Recommendation: Refuse

Applicant: Mrs Christine Robbins

Proposal: Extension to end of existing bungalow, raising of existing roof & loft conversion with box dormer to rear aspect. Erection of double garage.

North Elevation
1 : 100

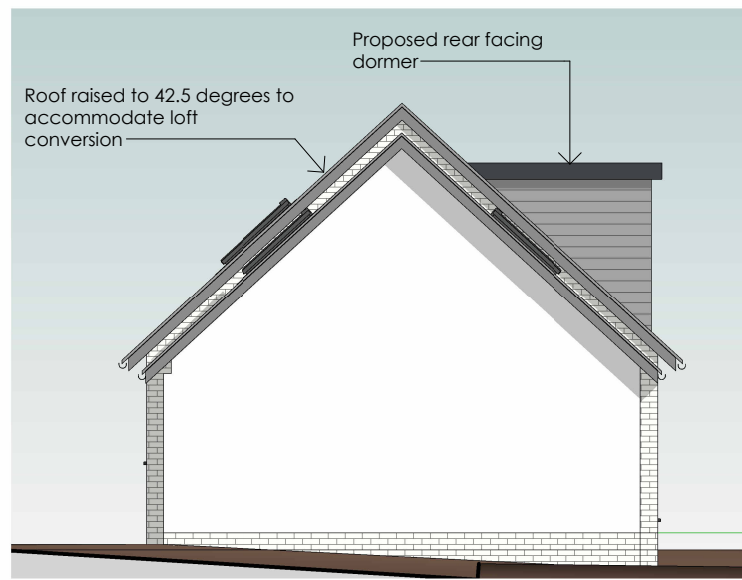
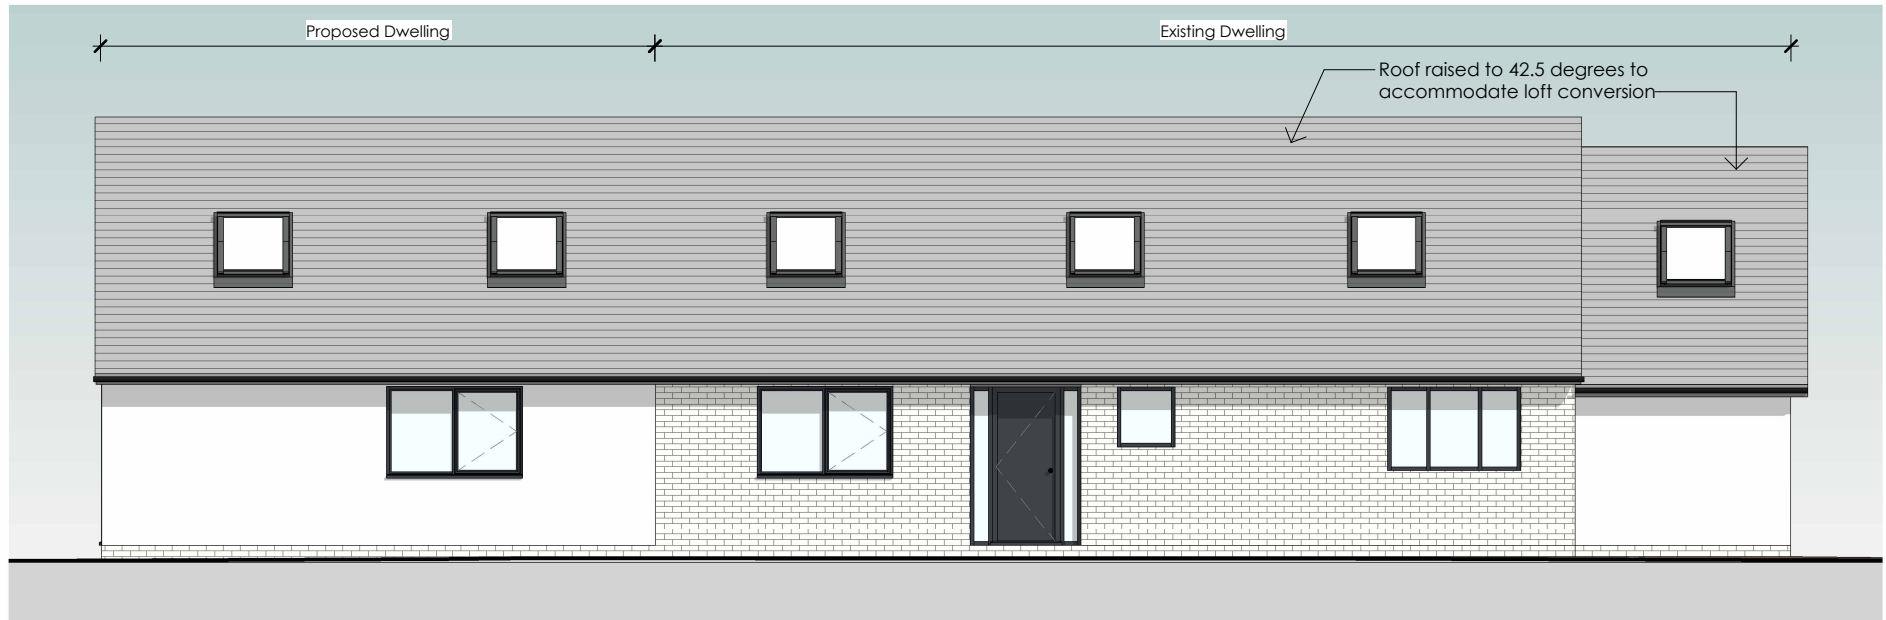
The proposed new side extension has a width of 7.35m and is flush with the front and rear of the dwelling. It is noted approval was given in 2020 for a replacement extension broadly in this position, but the width of the approved extension was 5m and had a 0.5m set back, and therefore the ridge was set down. Also proposed is a replacement extension on the other side, with a width of 2.85m. Cumulatively, the extensions would be 10.2m, whereas the width of the original bungalow is 12.2m. The extensions are disproportionate in their width, and the additional 2.35m extension would contribute to the property appearing overly dominant and visually incongruous in views from the defined Public Right of Way. Further, the smaller of the extensions has a blank front elevation, which is a poor form of design.

In addition to the excessive width of the extensions, there are concerns over the increased roof height. It is considered that the modest bungalow as existing would be overwhelmed by the extension and increased roof height together. The design of the increased roof height would have a top-heavy appearance, with a proliferation of 6 rooflights across the front elevation. The addition of 6 rooflights to the front draws attention to the increased scale, bulk and massing that is detrimental to the character of the property and the surrounding area. The roof increase, along with the width and rooflights, are not sympathetic additions to the host property, and would appear alien within the street scene.

1. The proposed development, by virtue of the scale of the side extensions, increased roof height and proliferation of rooflights, would result in a visually

South Elevation

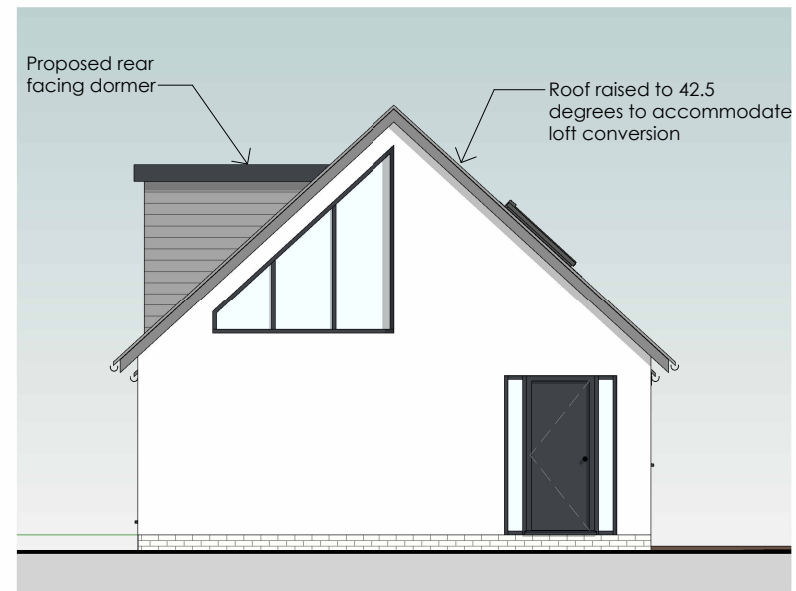
The proposed rear dormer is a box dormer with a length of 16.7m. Due to the position on the edge of the village, this property is highly visible from the adjacent Public Right of Way, along with views from the open countryside. The proposed dormer is overly large, overwhelms the roof plane, and is an incongruous feature that would adversely affect the visual amenity of the area.

2. The proposed dormer window, by virtue of its excessive mass, scale and design results in an incongruous form of development that fails to sympathetically integrate with the existing bungalow, the built environment or reinforce local distinctiveness and would adversely affect the character and appearance of the area. The proposal is therefore contrary to Policy ESD15 of the Cherwell Local Plan 2011-2031 Part 1, saved Policies C28 and C30 of the Cherwell Local Plan 1996, Cherwell's Home Extension and Alteration Design Guide SPD 2007, and Government guidance contained within the National Planning Policy Framework.

North Elevation Garage

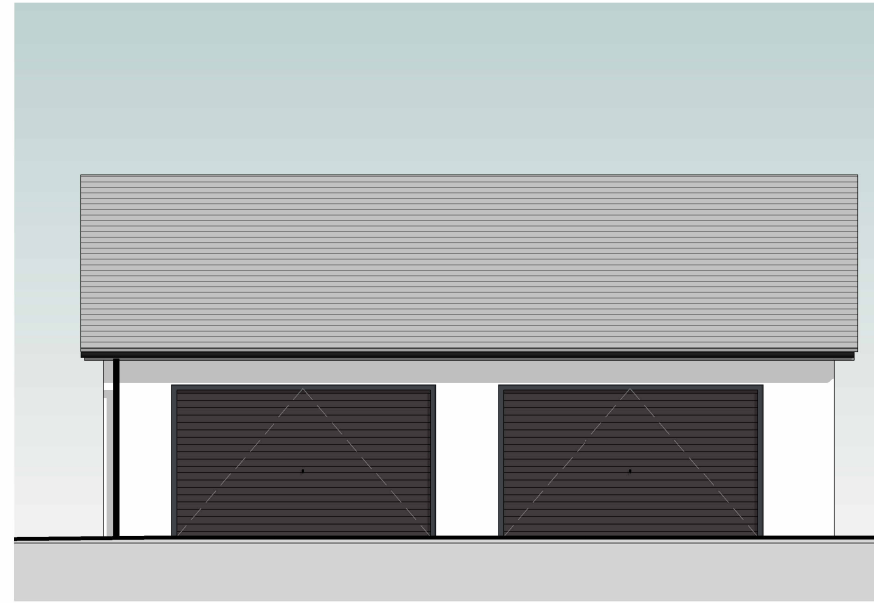
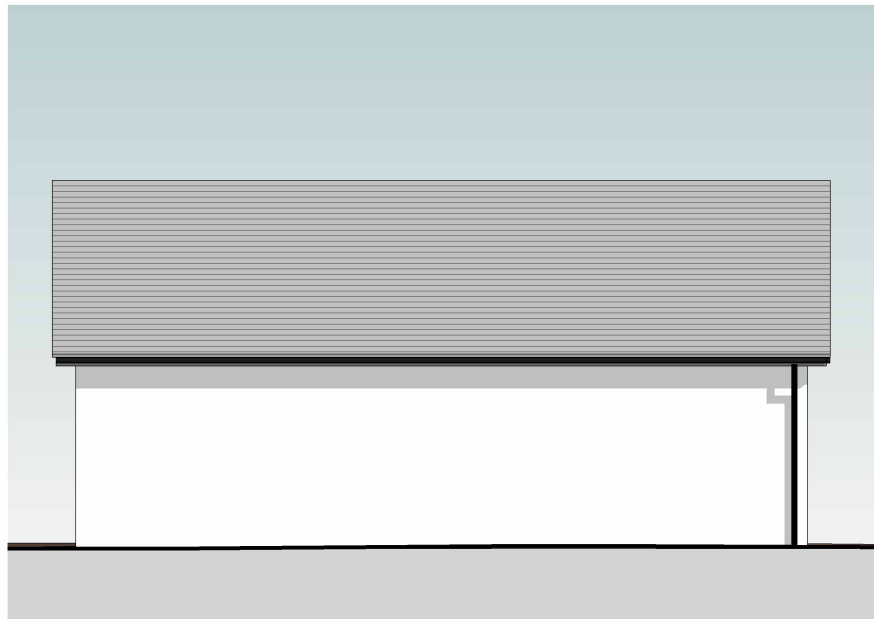
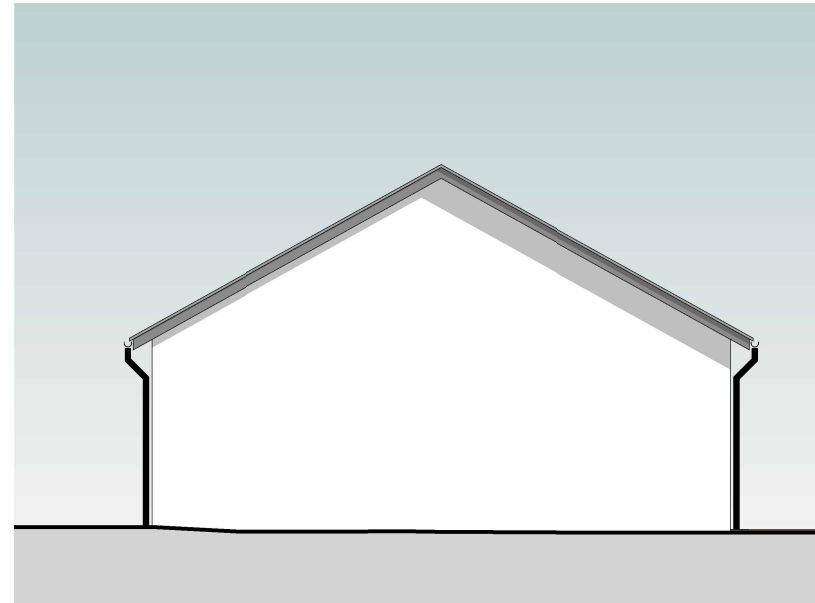
Although large and rather visually obtrusive, the detached garage is considered acceptable on the basis that it was granted permission in July 2020, and there have been no significant policy changes that would alter the assessment. While the previous approval is not an extant permission, it would be considered unreasonable to object to this element of the application considering the lack of change in the policy position. The length of the proposed garage has decreased by 1m, the width increased by 0.65m, and the height increased by 0.2m. These changes from the previous approval are considered not to have any significant bearing on the proposal's impacts.
